From: Amanda Scholes on behalf of Planning.Responses
Sent: 16 October 2019 08:25
To: Planning Scanning
Subject: FW: BR/120/19/PL, BR/121/19/L, The Bandstand

From: Maria Tomalova [REDACTED]
Sent: 15 October 2019 14:27
To: Phil Brown [REDACTED]
Subject: BR/120/19/PL, BR/121/19/L, The Bandstand

Please find below the comments of our Conservation Officer:

A	MINOR AMENDMENT	16.04.19
REV	DESCRIPTION	DATE
PROJECT	BOGNOR REGIS BANDSTAND	
	THE ESPLANADE	
	BOGNOR REGIS	
	WEST SUSSEX	
DRAWING TITLE	PROPOSED ELEVATIONS, FLOOR PLAN AND ROOF PLAN

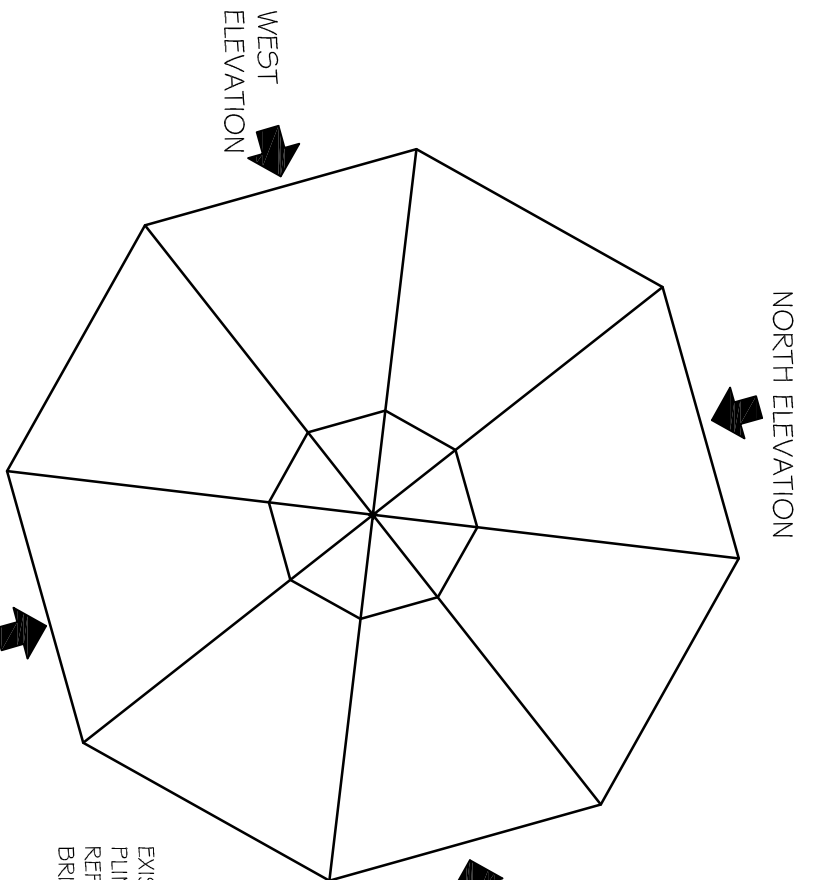
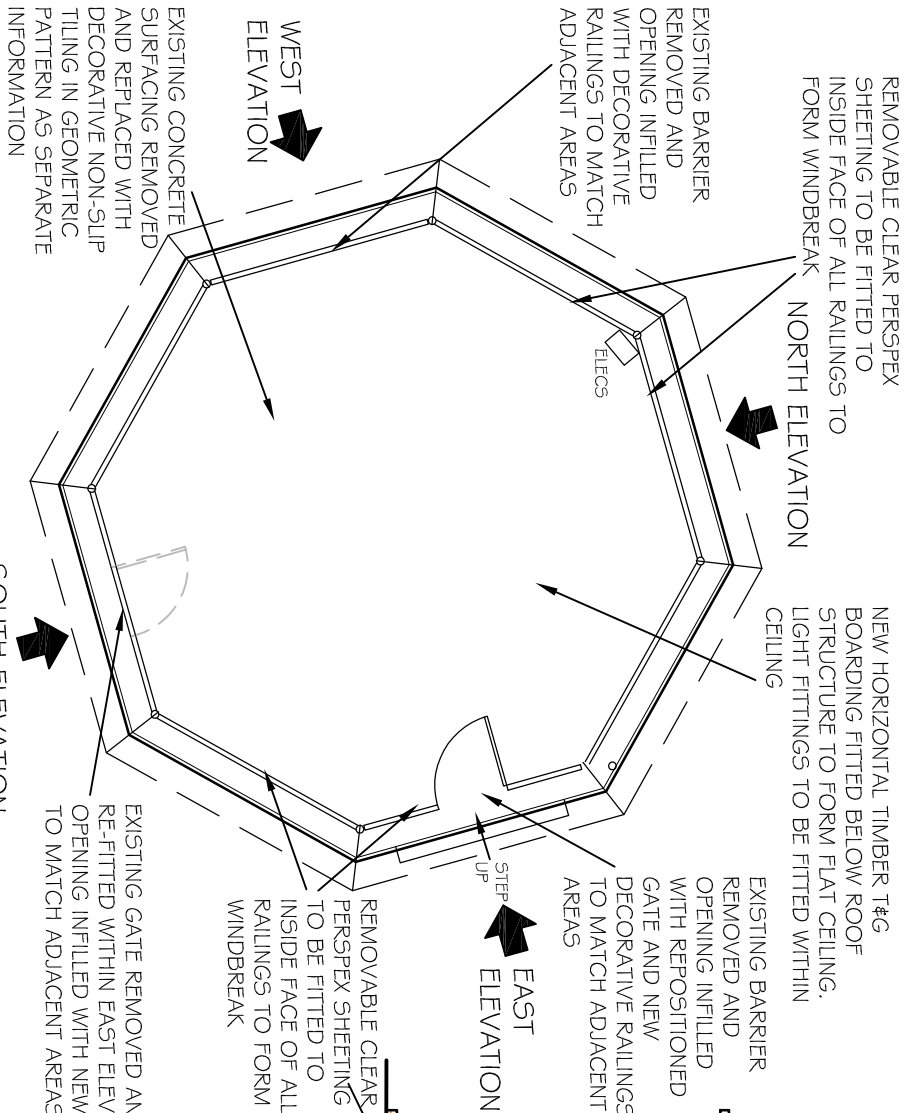
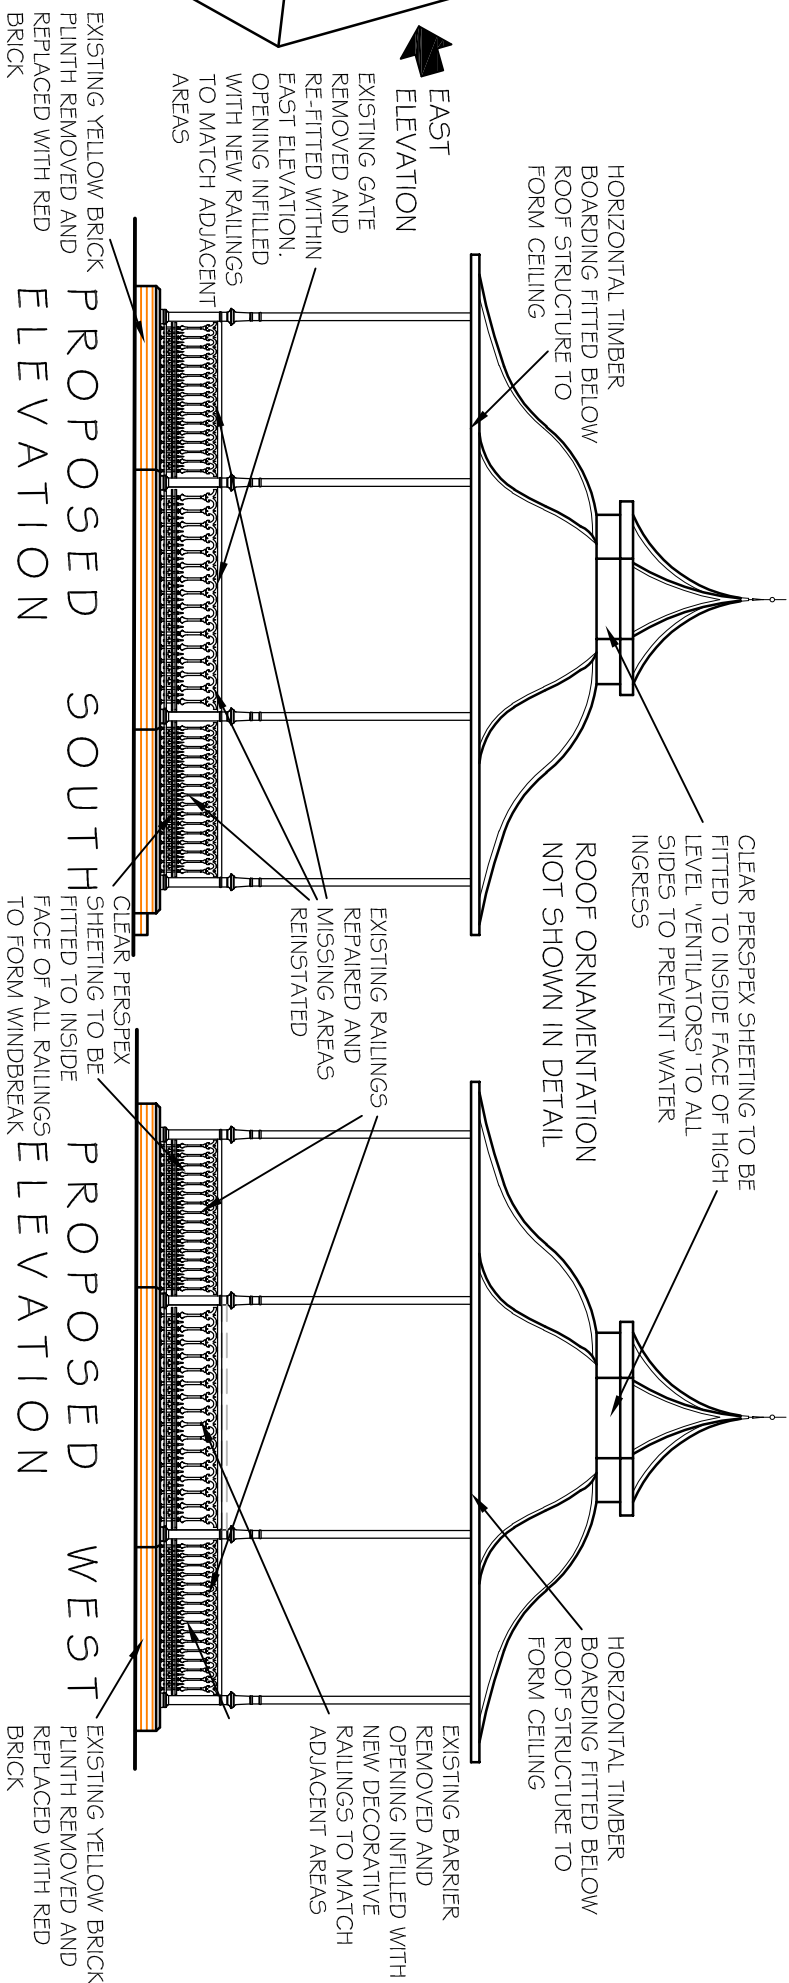
However, there are some issues which require clarification. It is not clear from reviewing the information why the location of the gate is to change.

- **Relocation of access gate.** The Bandstand has previously been disassembled and re-assembled and is not in its original location. There is no particular historic or architectural significance related to the current positioning of the access gate except that it faces directly onto the seafront. The balustrading and handrail (and associated access gate) are relatively interchangeable between the main structural support posts as the structure is a regular, symmetrical shape. The relocation of the gate will position it where there is currently an access step, which would seem an entirely logical location as this position would enable easy access and egress without disturbing the main thoroughfare along the promenade.

REV	DESCRIPTION	DATE
PROJECT BOGNOR REGIS BANDSTAND THE ESPLANADE BOGNOR REGIS WEST SUSSEX		
DRAWING TITLE REFLECTED CEILING PLAN AND LIGHTING PLAN

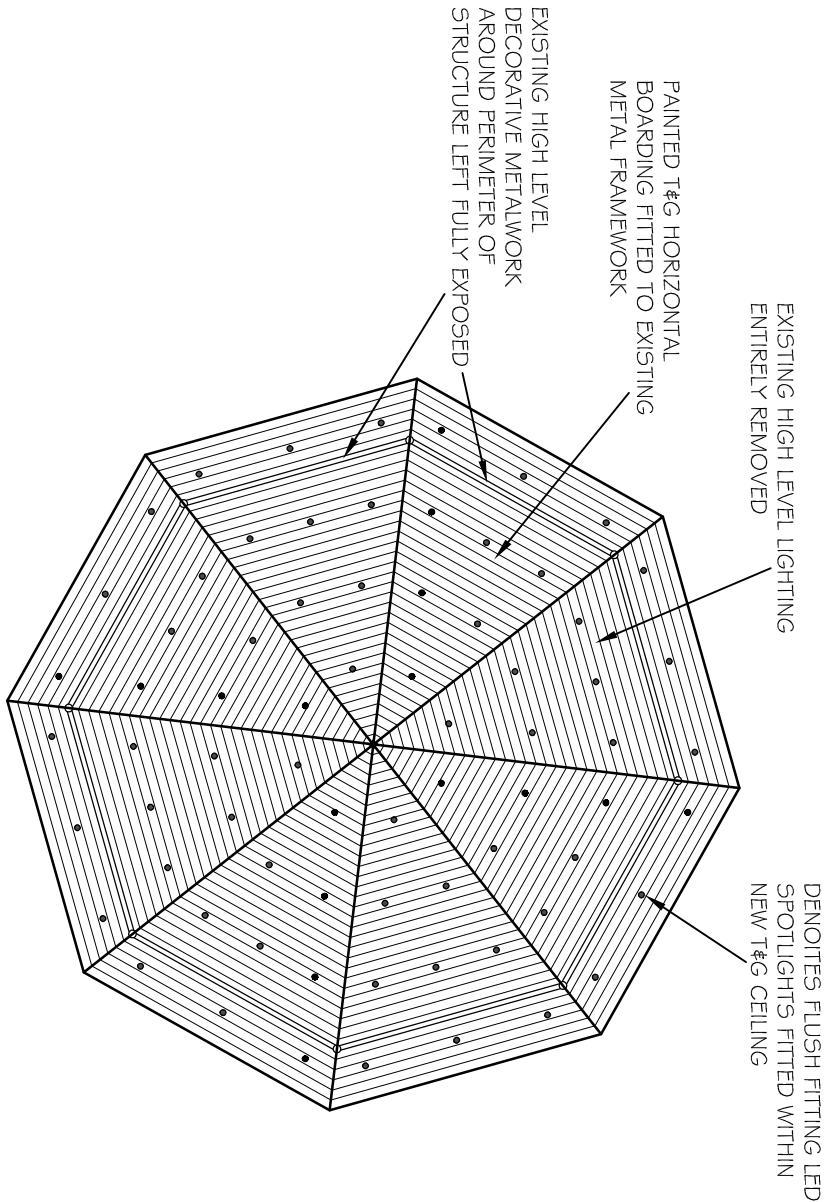
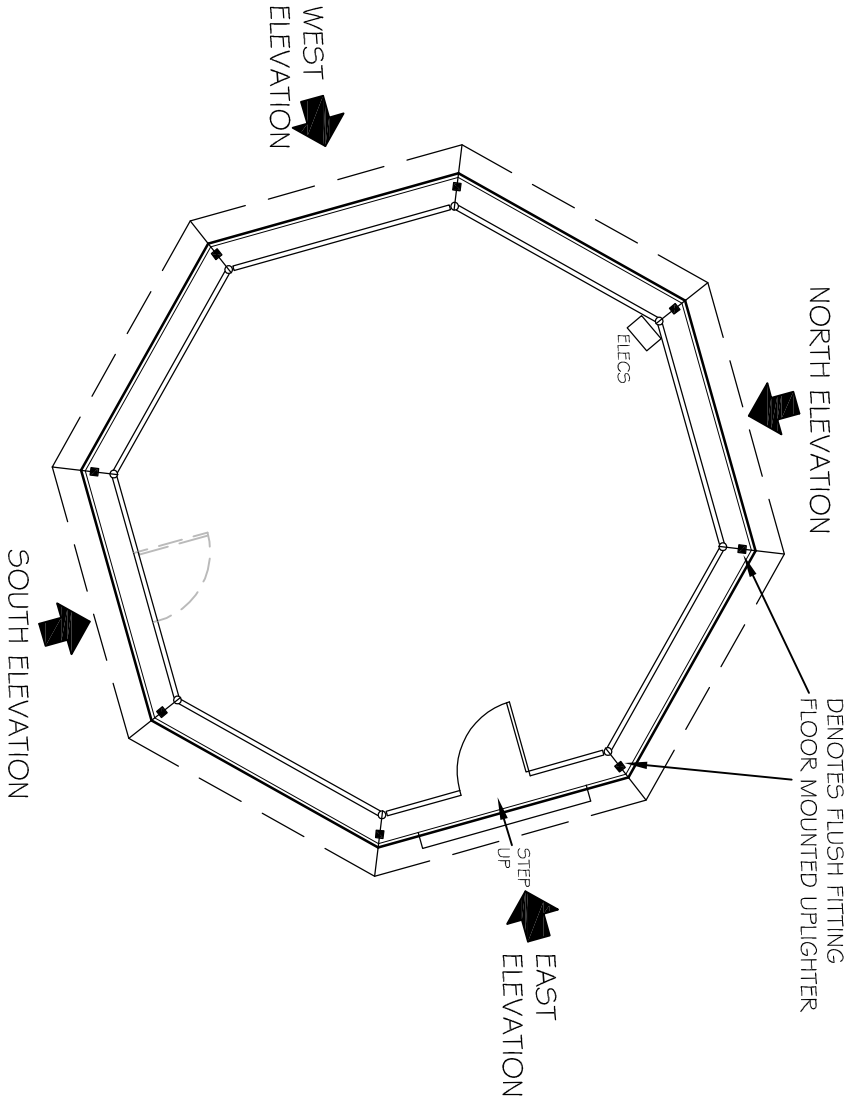
Also how will the horizontal timber boarding to be fitted below the roof structure to form a ceiling be treated?

- **Timber ceiling boarding.** The new timber boarding will be fitted to existing horizontal metal framework and would have a painted finish.
- **Materials.** We accept that a suitably worded condition will need to be applied to agree the details of the new bricks and other items.
